HISTORIC PRESERVATION BOARD

July 22, 2005

Re: 19 Lewis Street – Extension of Existing Fire Escape

PLAN VIEW
SECOND FLOOR

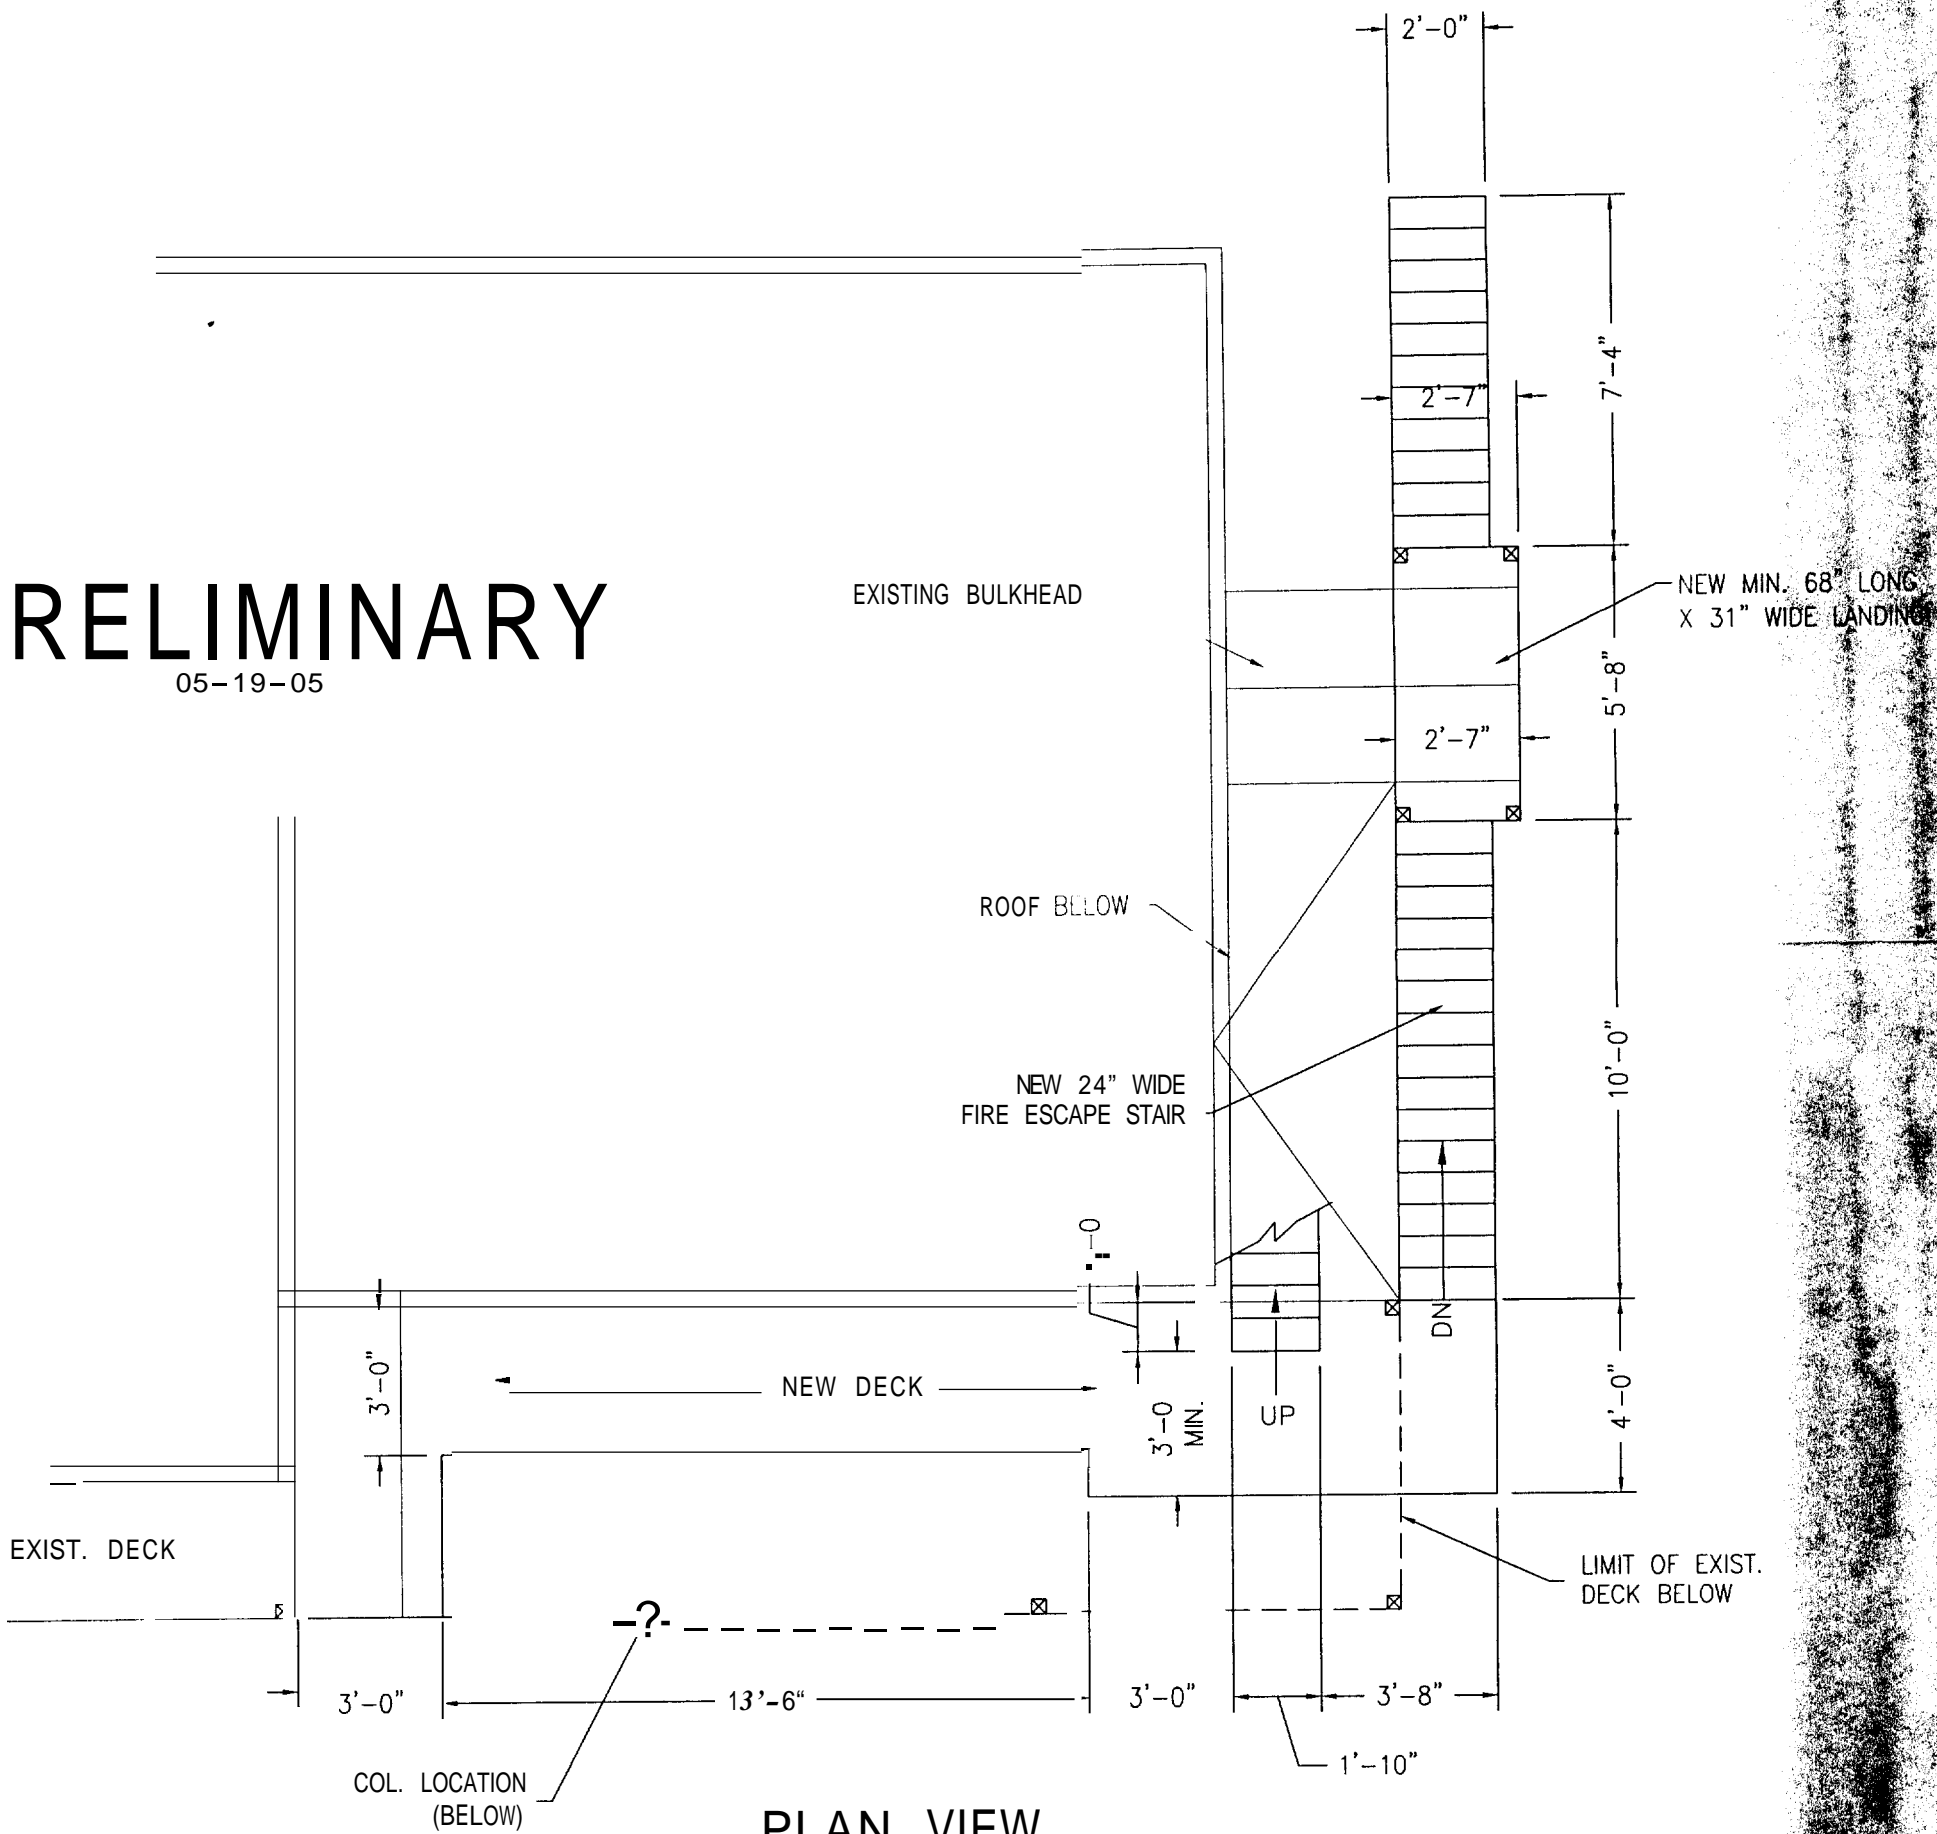
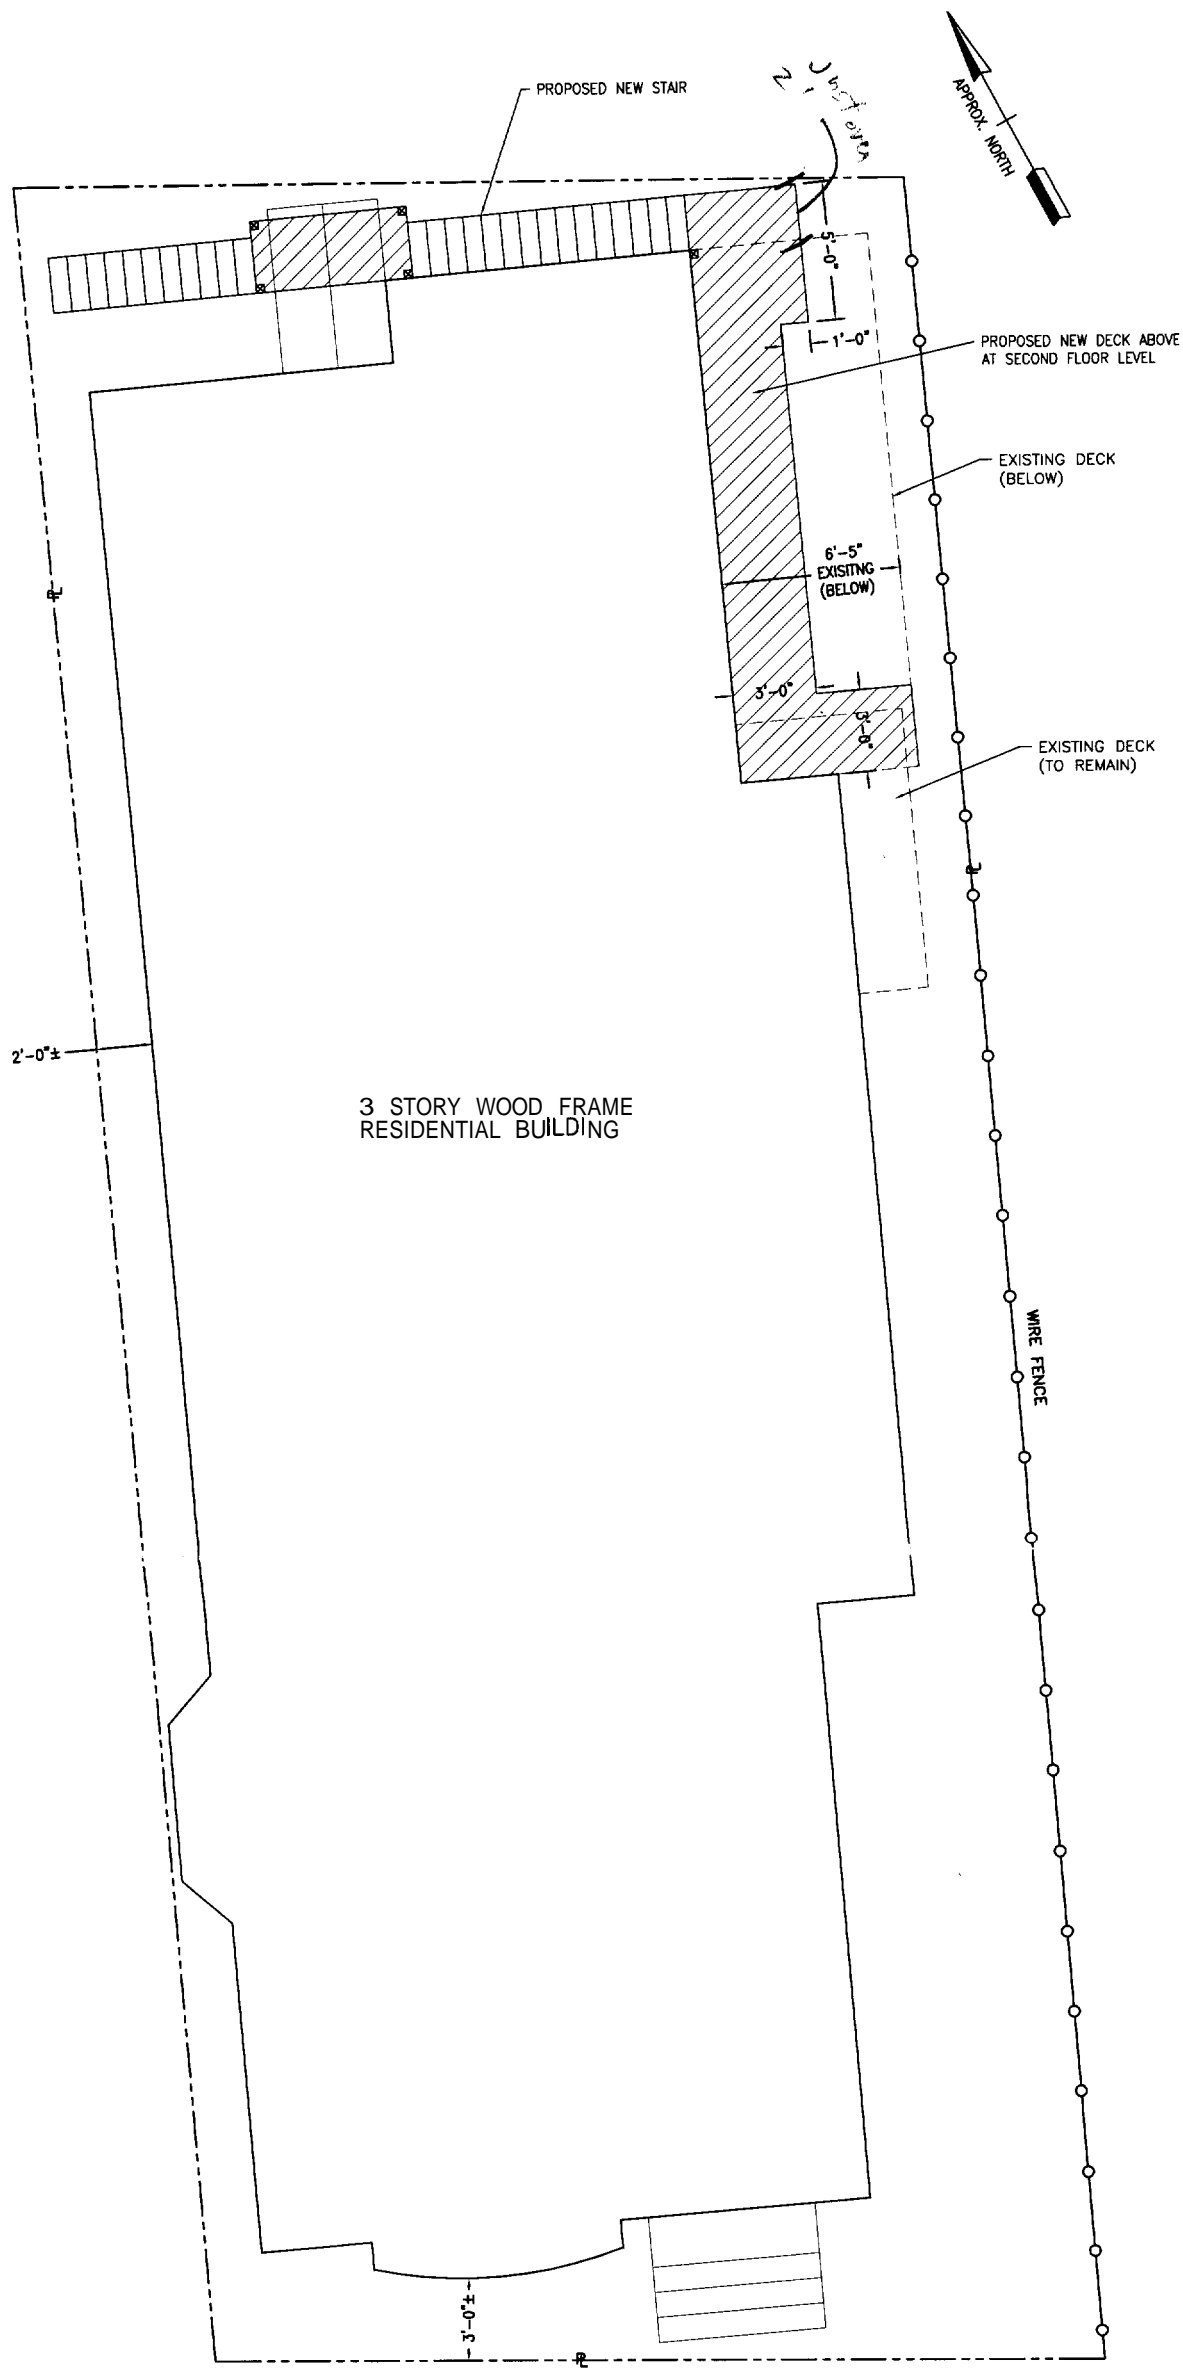
- The submitted plan shows two projections in the standard width of the second floor decking. These projections are to be eliminated.
- All railings are to be painted or opaque stained to match the color of the body of the house.
